Final Drainage Report

Ellicott School Addition - 2 Buildings

Project No. 61183

September 1, 2022

MVE PROJECT 61183
MVE DRAWING DRAIN-EX-1

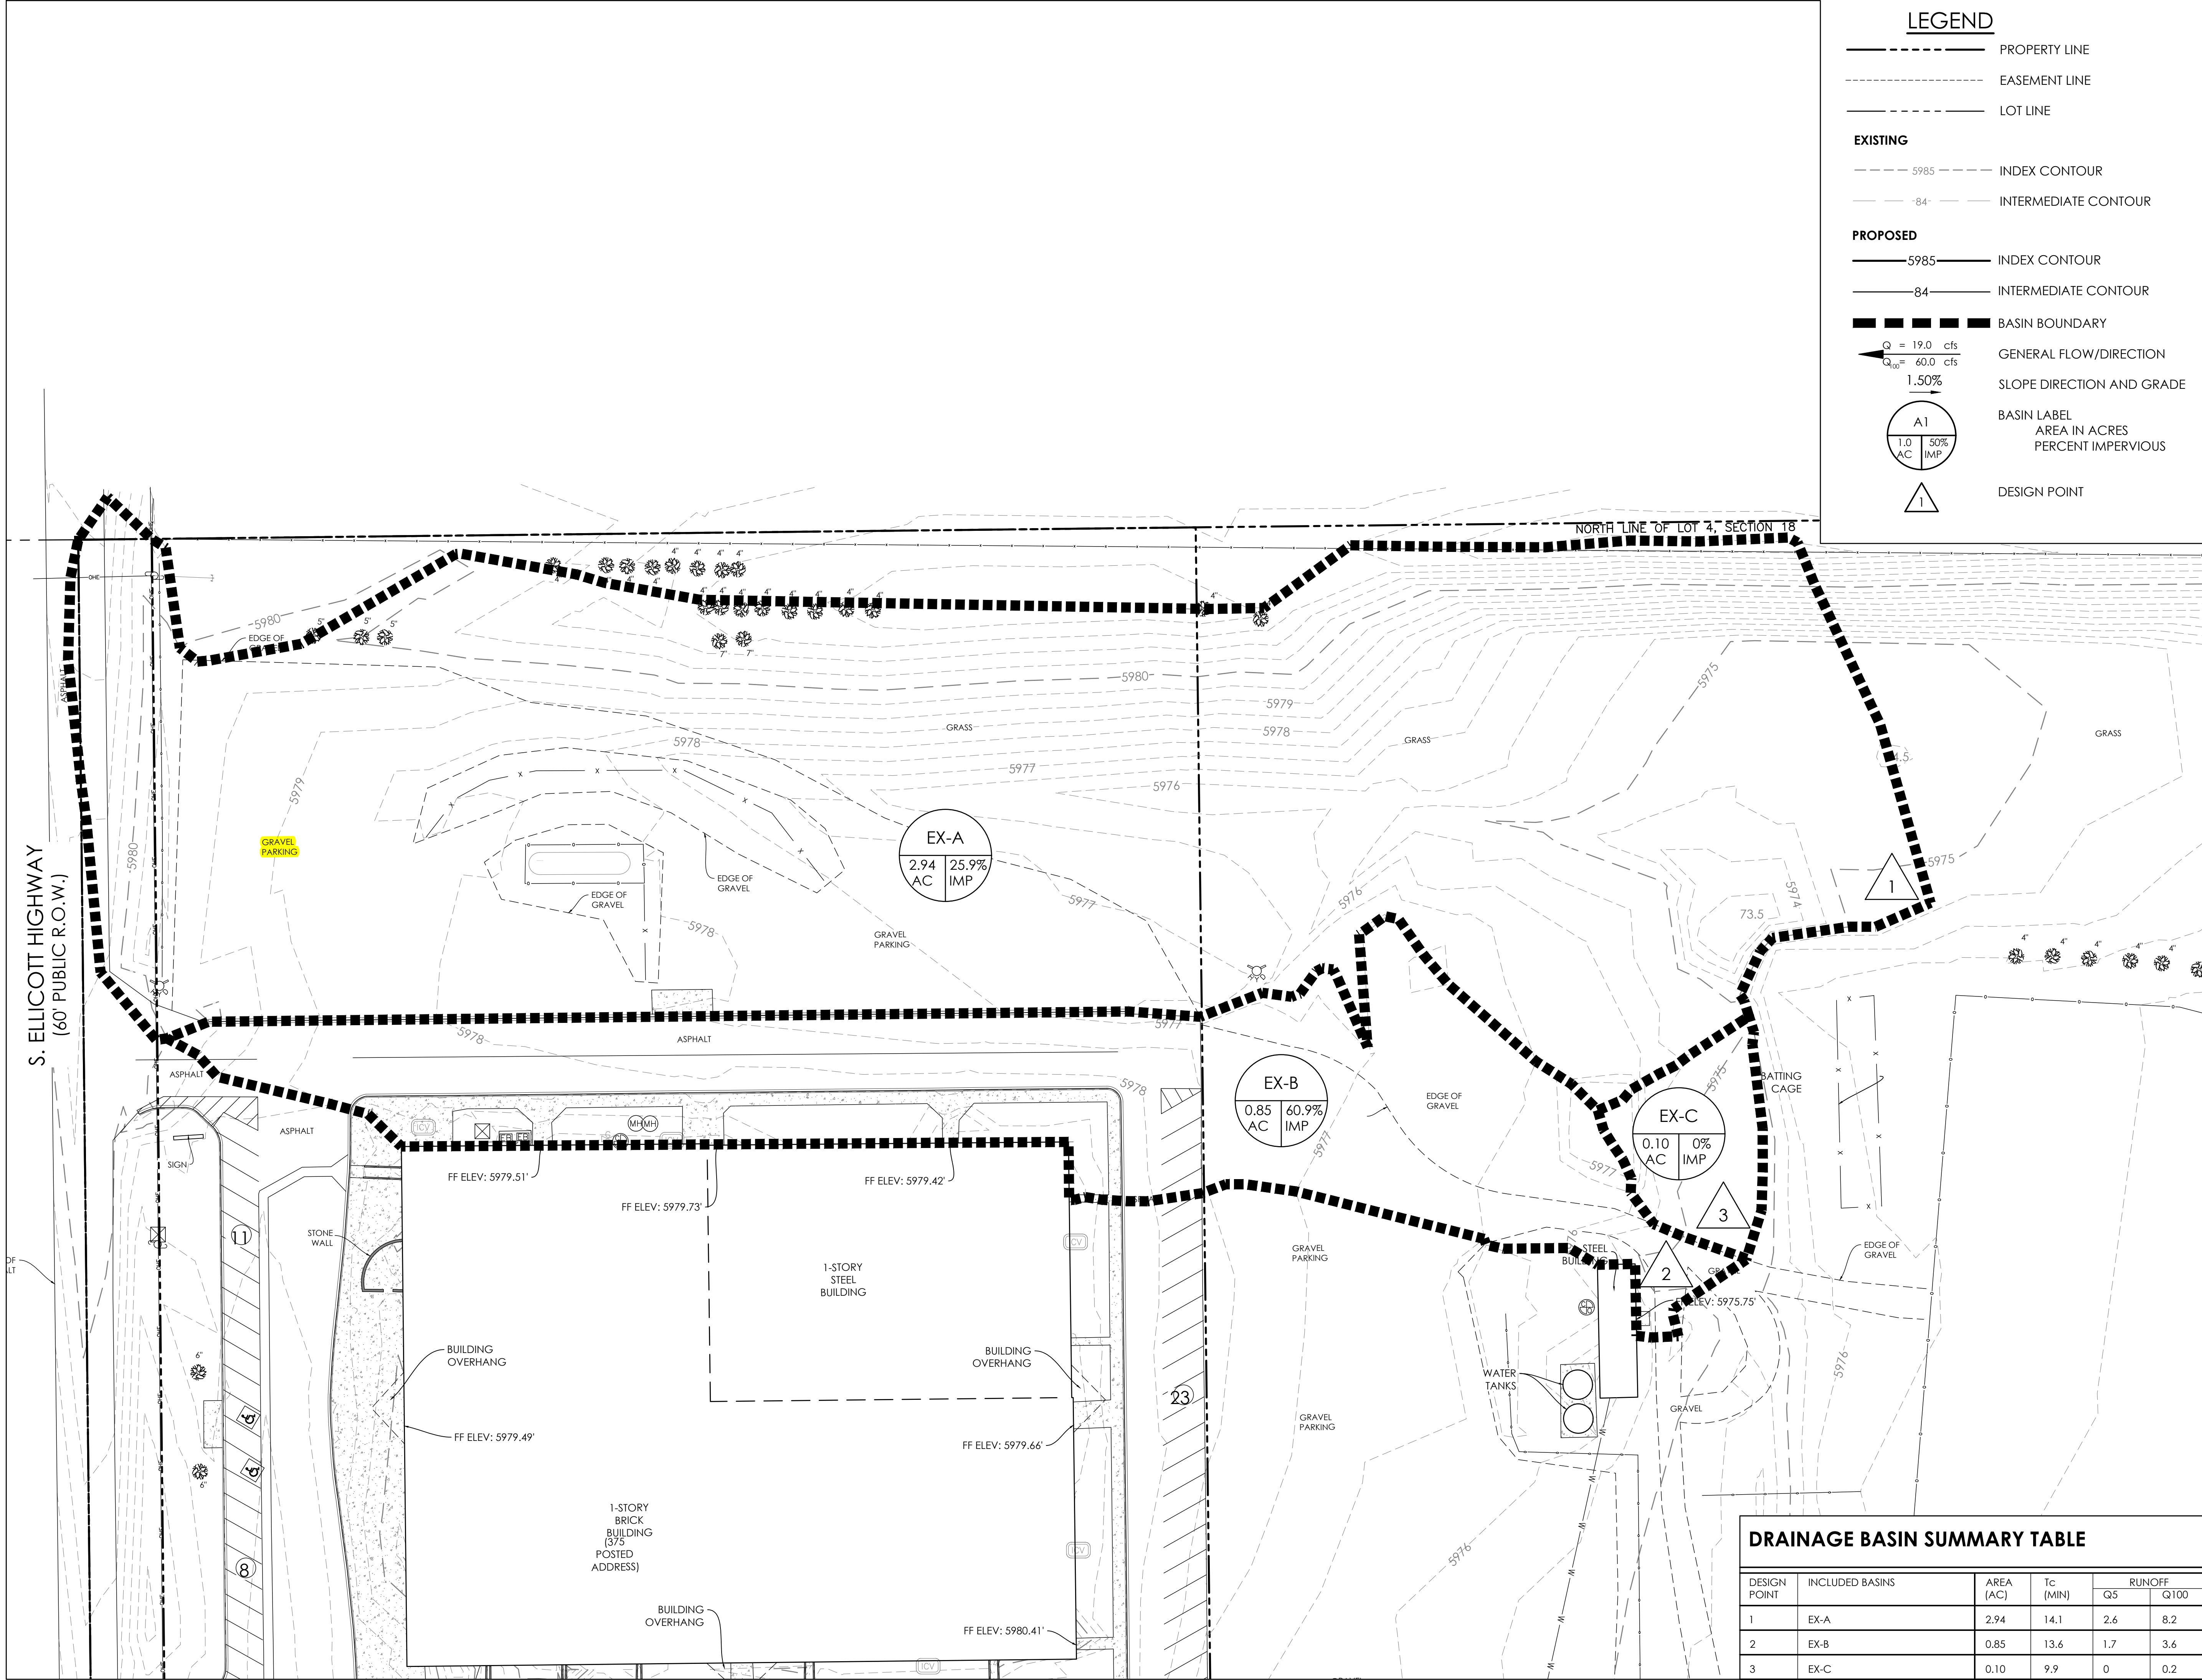
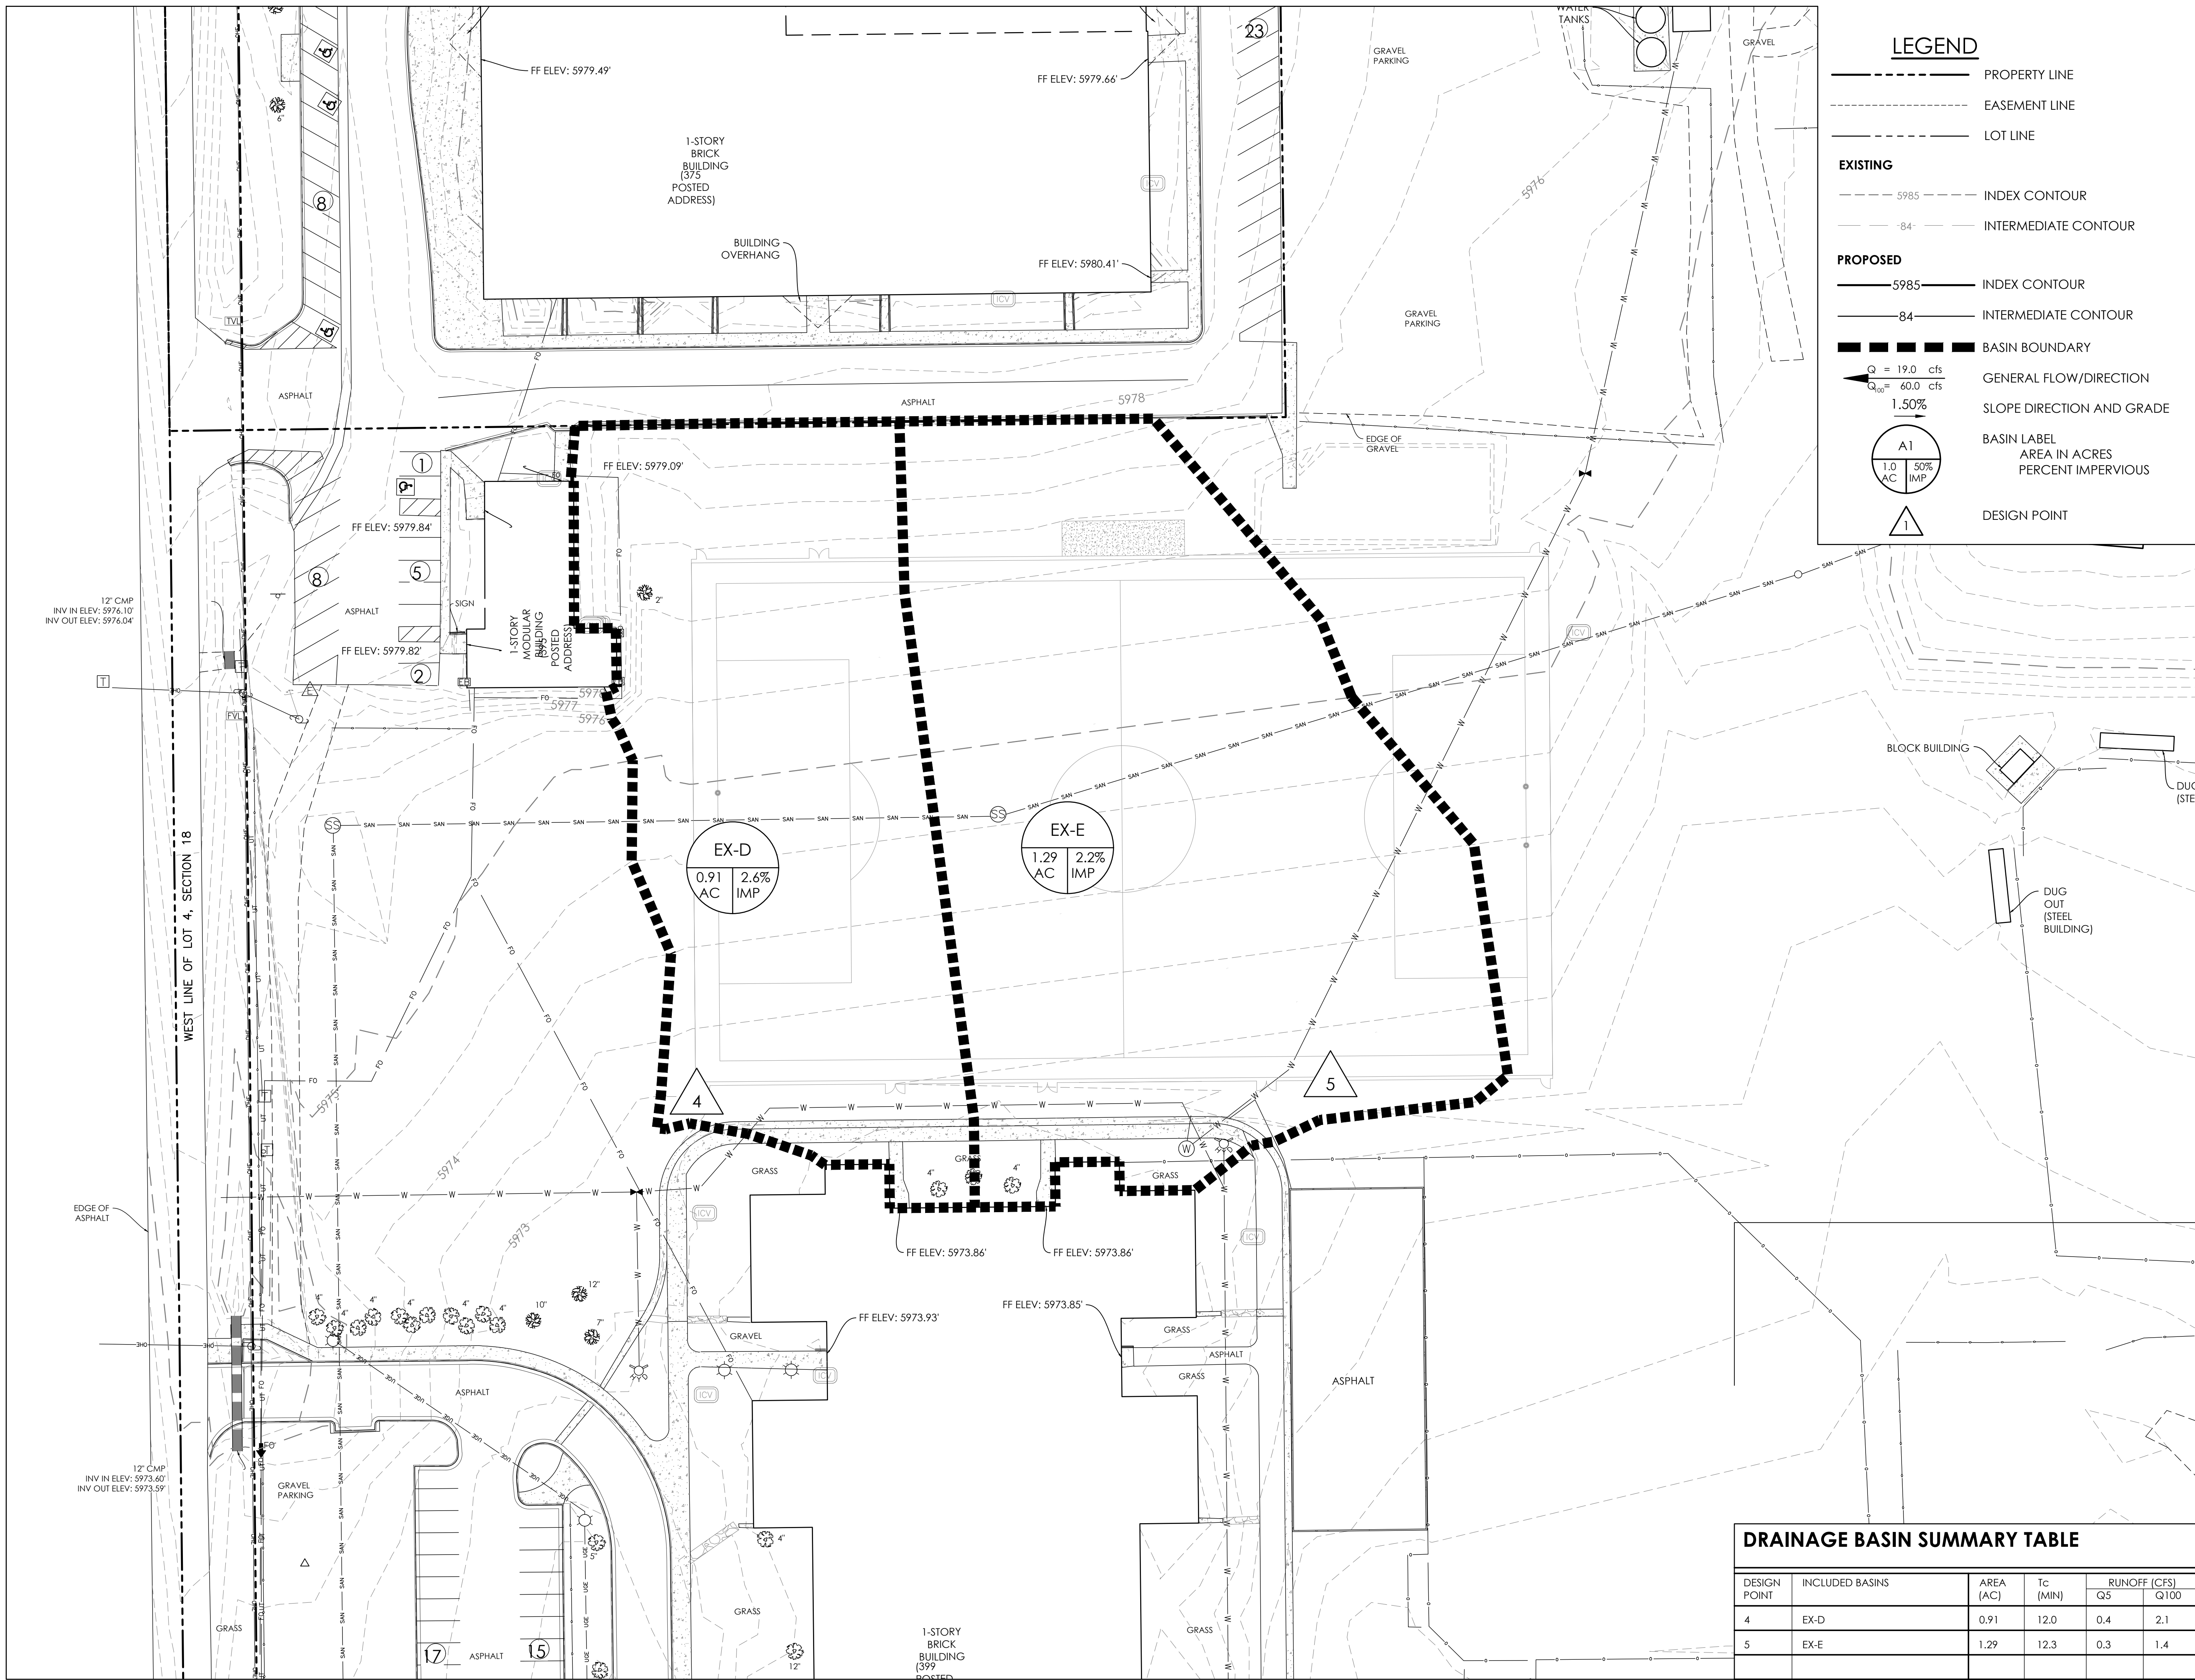
See comments on drainage maps

Provide discussion and analysis of existing roadside ditches along property and Handle Road and capacity to handle total flows from property
